**KIRKLEES METROPOLITAN COUNCIL  
INVESTMENT & REGENERATION SERVICE**

**Reference No:** 2020/62/93329/W

**Site Address:** adj, 42A, Station Road, Fenay Bridge, Huddersfield,  
HD8 0AD

**Description:** Erection of one dwelling and associated works

Floor Plans to Proposed Dwelling		
Station Road		
Fenay Bridge		
HD8 OAD		
Date	Sept 20	Dwg no
		02
Drawn By		Scale
		A3 - 1:50

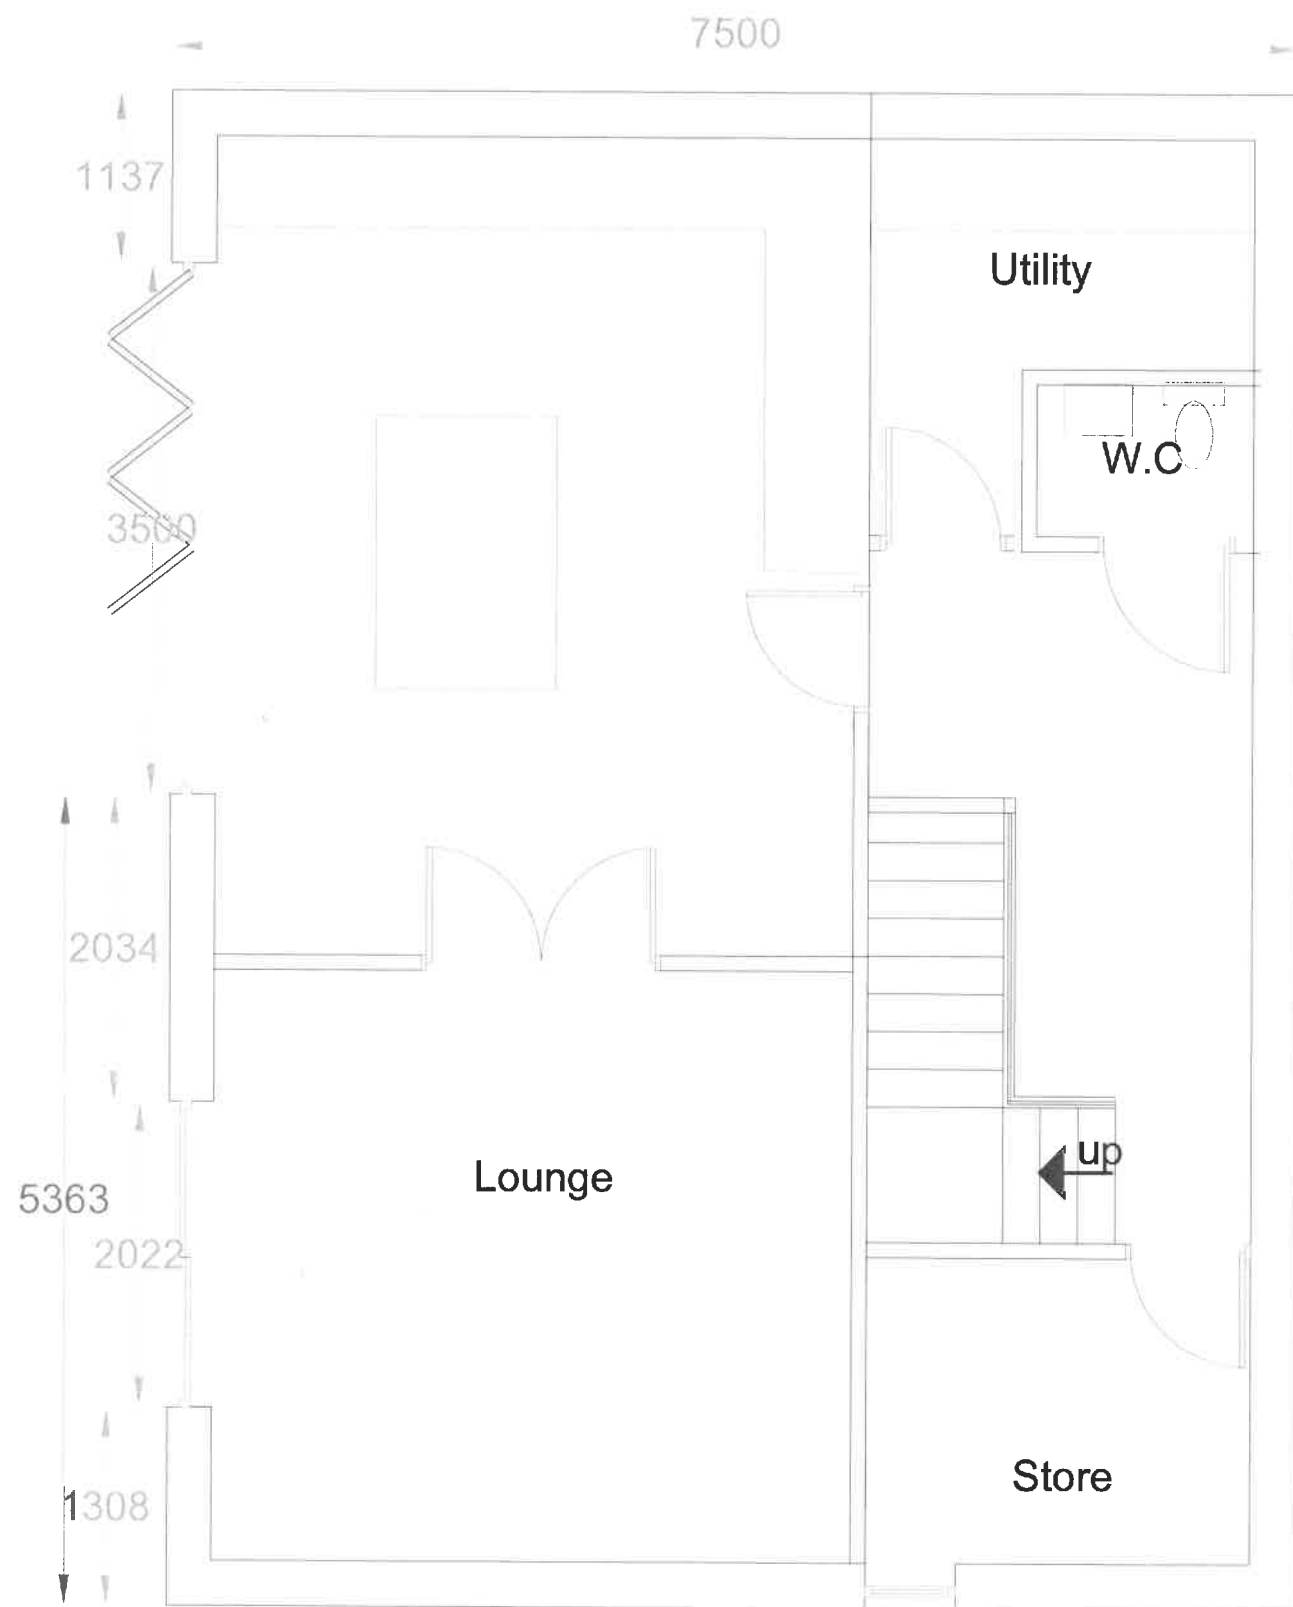
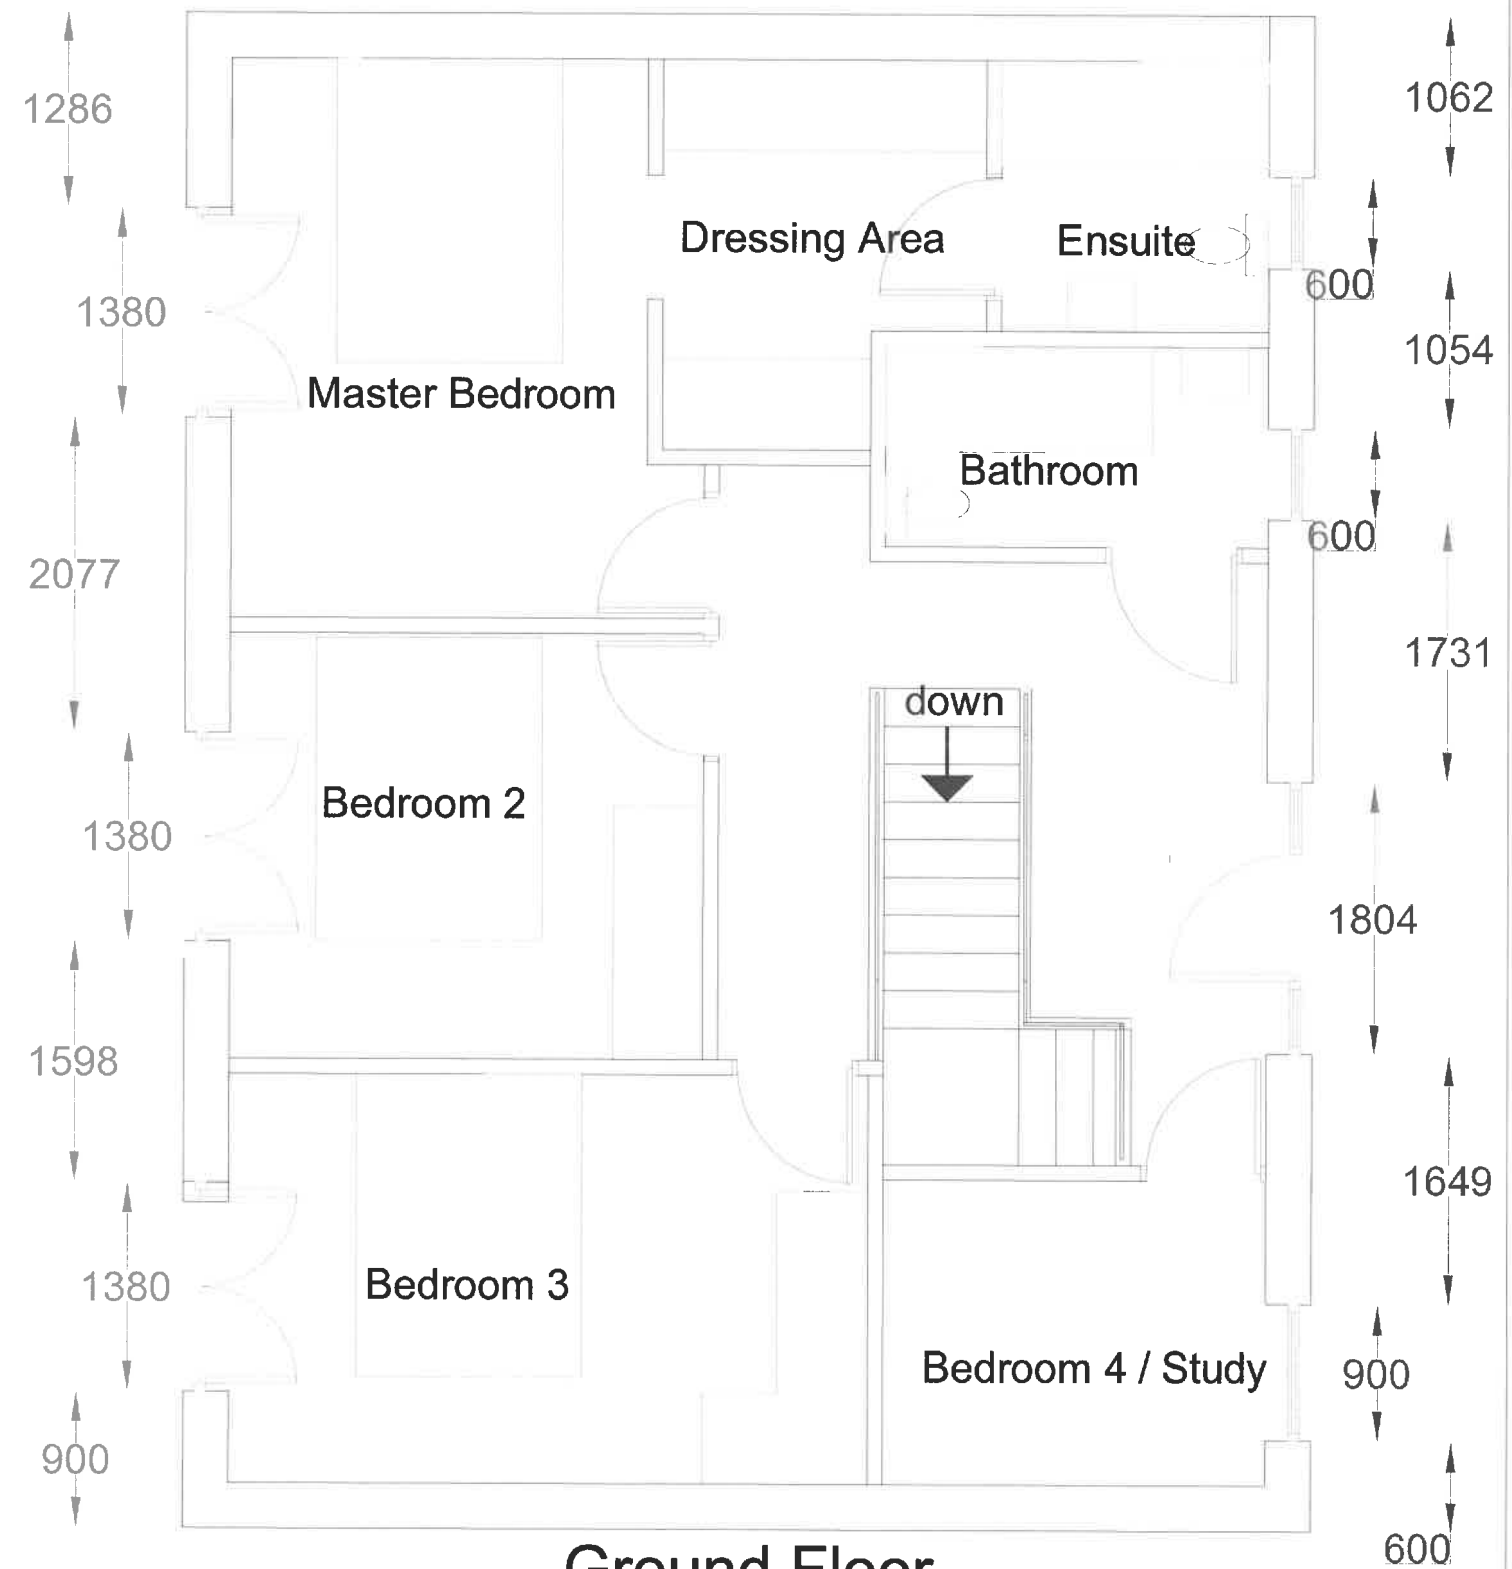
It is considered that views from rear facing windows within the proposed dwelling would be extremely oblique views of the very rear garden of No.42a. A ground floor window is proposed in the south side elevation of the dwelling, but suitable boundary treatment on the shared boundary will help to prevent clear views into the side windows within No.42a and the rear garden. This can be conditioned, and subject to this, it is considered that the proposal would not cause undue harm to No.42 in terms of loss of privacy or overlooking.
